CITY OF ALBUQUERQUE  
 PLANNING DEPARTMENT  
 DEVELOPMENT REVIEW BOARD

10DRB-70344 MAJOR – SITE DEVELOPMENT PLAN FOR BUILDING PERMIT

APPLIED ENGINEERING & SURVEYING agent(s) for NM EDUCATORS FEDERAL CREDIT UNION request(s) the referenced/ above action(s) for Tract 2A, Block F, **BEVERLY WOOD ADDITION**, zoned SU-3/ MU-UPT (Mixed Use – Uptown Sector Plan), located on the southeast corner of INDIAN SCHOOL RD NE and AMERICA’S PARKWAY NE containing approximately 0.40 acre. (J-18)

PARKING LOT LAYOUT SITE PLAN

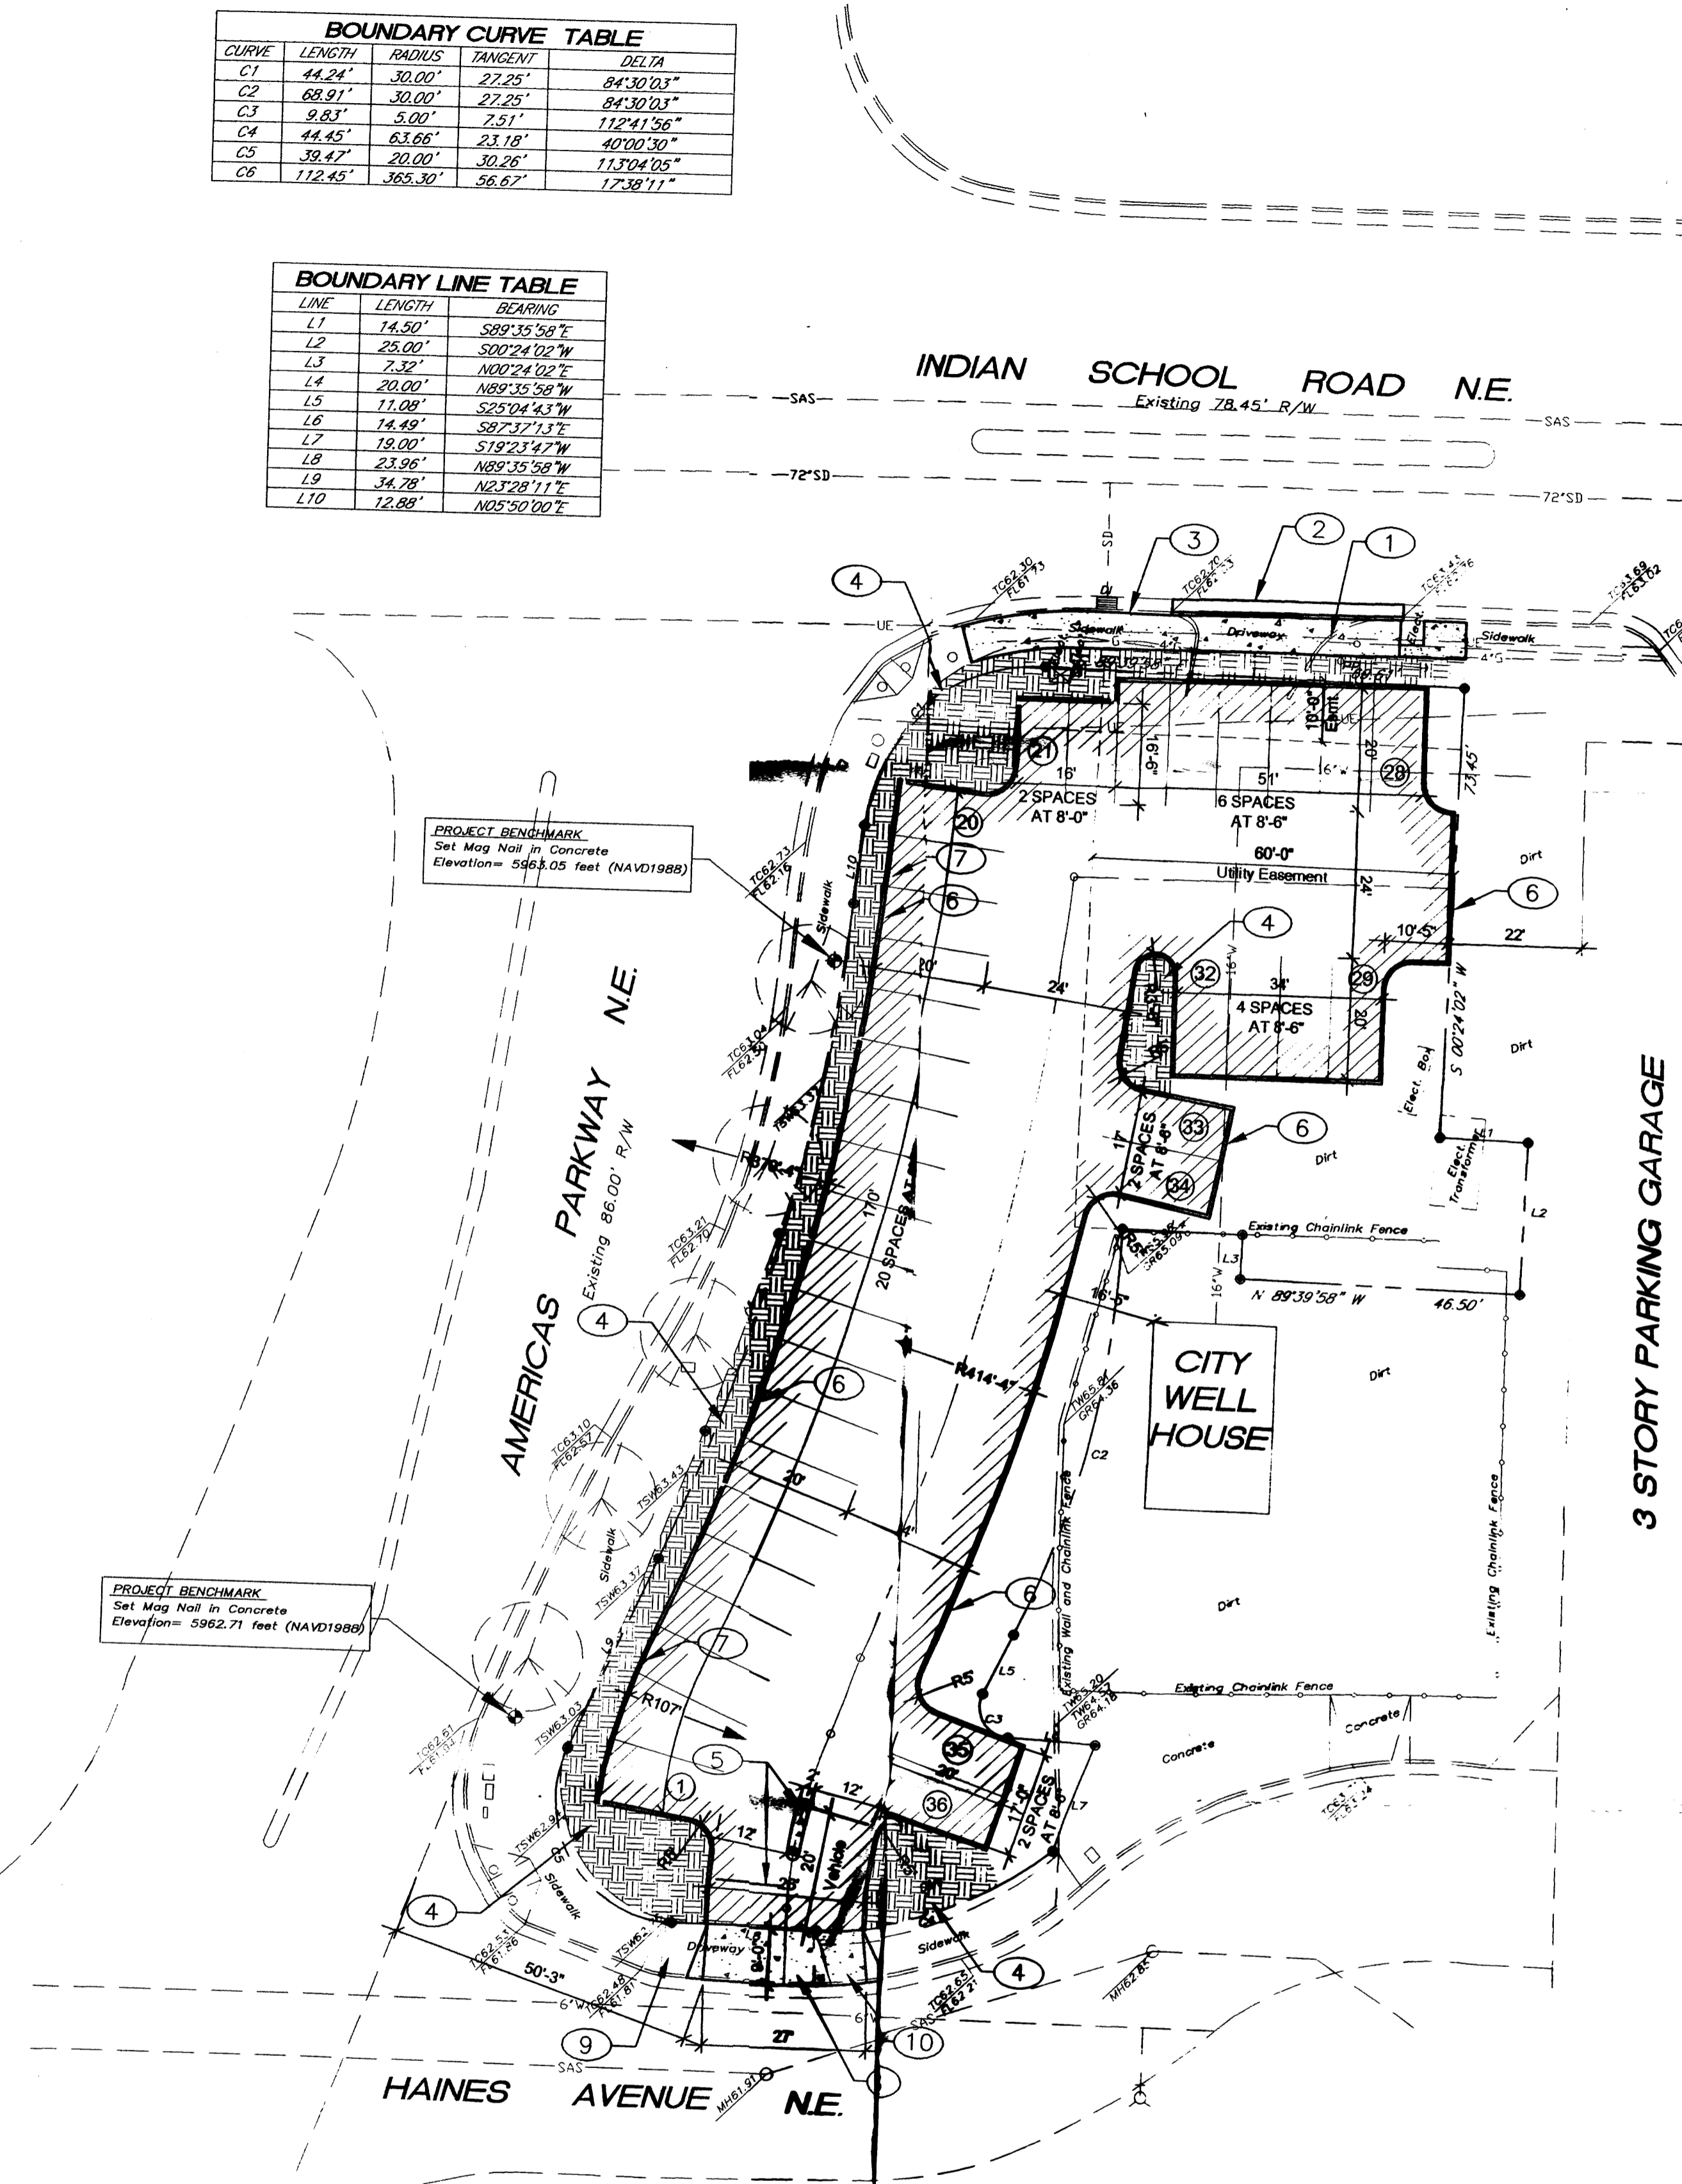
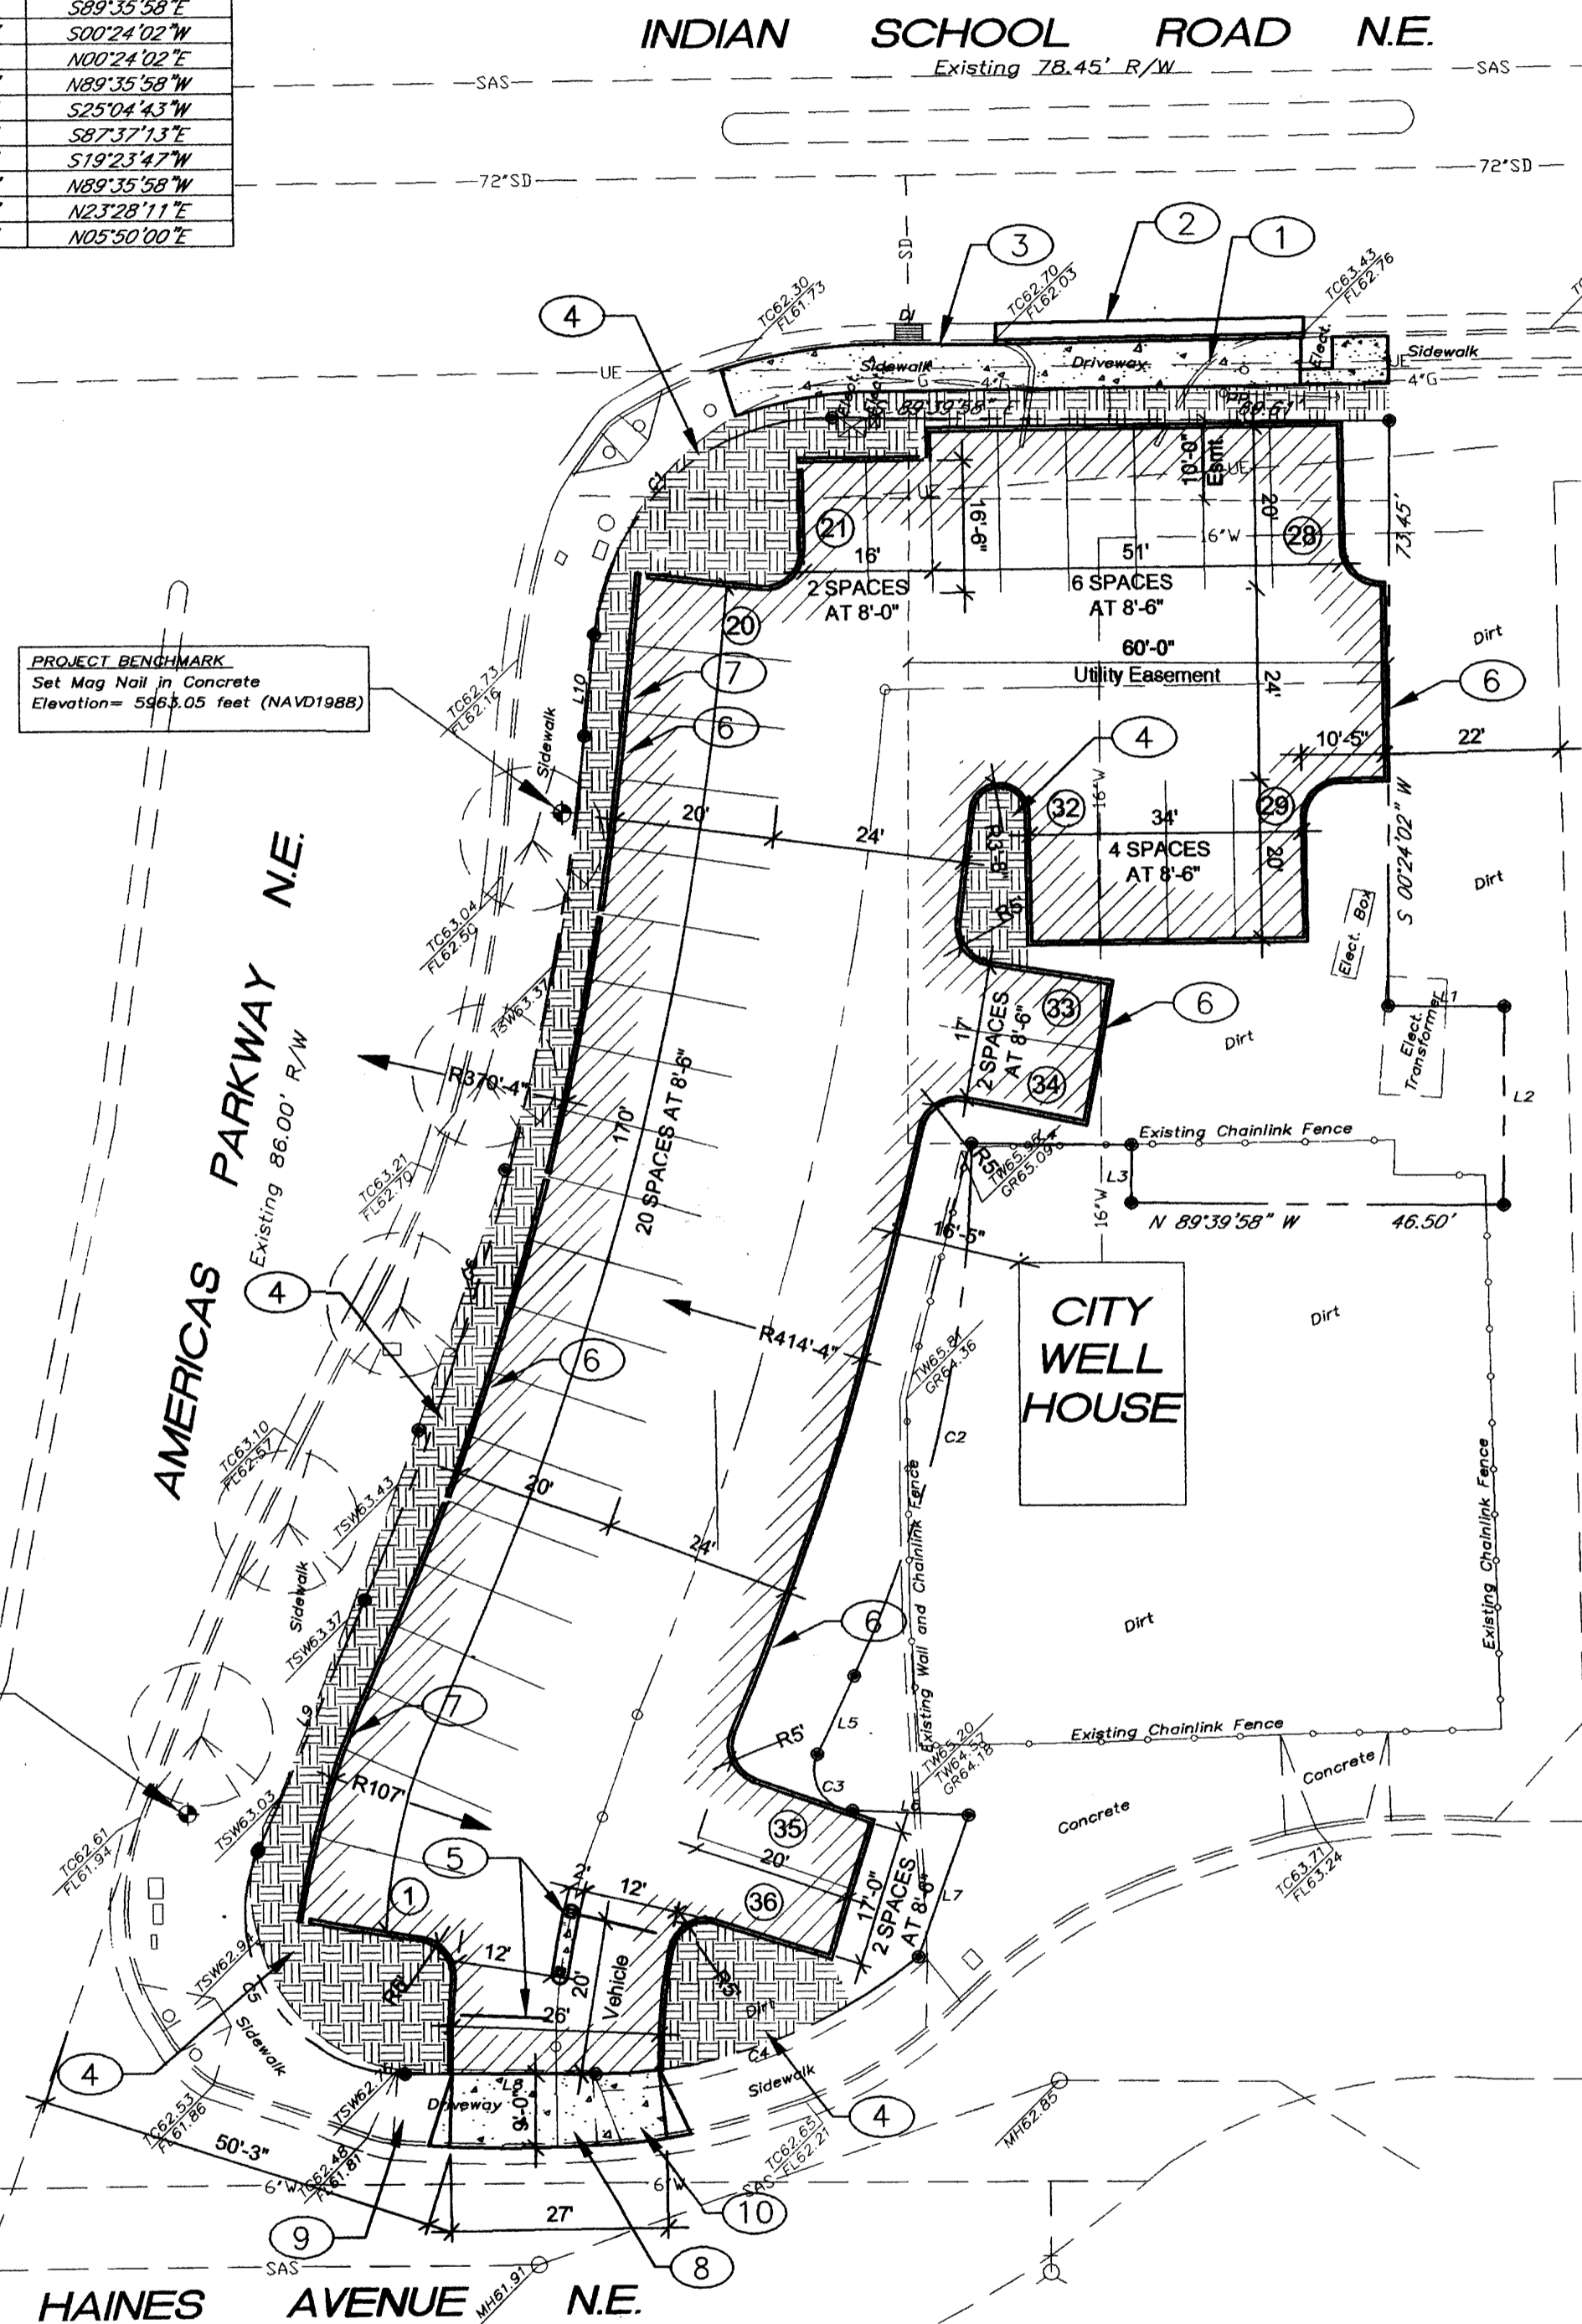
<b>PNM ELECTRIC</b> No comments
<b>NM GAS</b> For future and current easements required for the use of (NMGCO) gas lines are required. Please have the Future developers call New Mexico Gas Company for New Service Delivery and planned development in and around NMGCO'S distribution gas lines.  Mark Bouchard at (505) 697-3144. Distribution
<b>COMCAST</b> No comments
<b>QWEST</b> No comments
<b>ENVIRONMENTAL HEALTH</b> No comments
<b>M.R.G.C.D</b> No comments
<b>OPEN SPACE DIVISION</b> Open Space has no adverse comments
<b>CITY ENGINEER</b> No adverse comments.
<b>TRANSPORTATION DEVELOPMENT</b> Call out the width of all sidewalk. A portion of the public sidewalk at the intersection of Haines Avenue / Americas Parkway is located outside of the right of way. A public sidewalk easement is required. Parking spaces 1 and 2 (southwest corner of site) do not have sufficient maneuverability around the badge entry system. Please remove these spaces. Call out the width of the keyway. Label the compact parking spaces by placing the words "compact" on the pavement of each space.
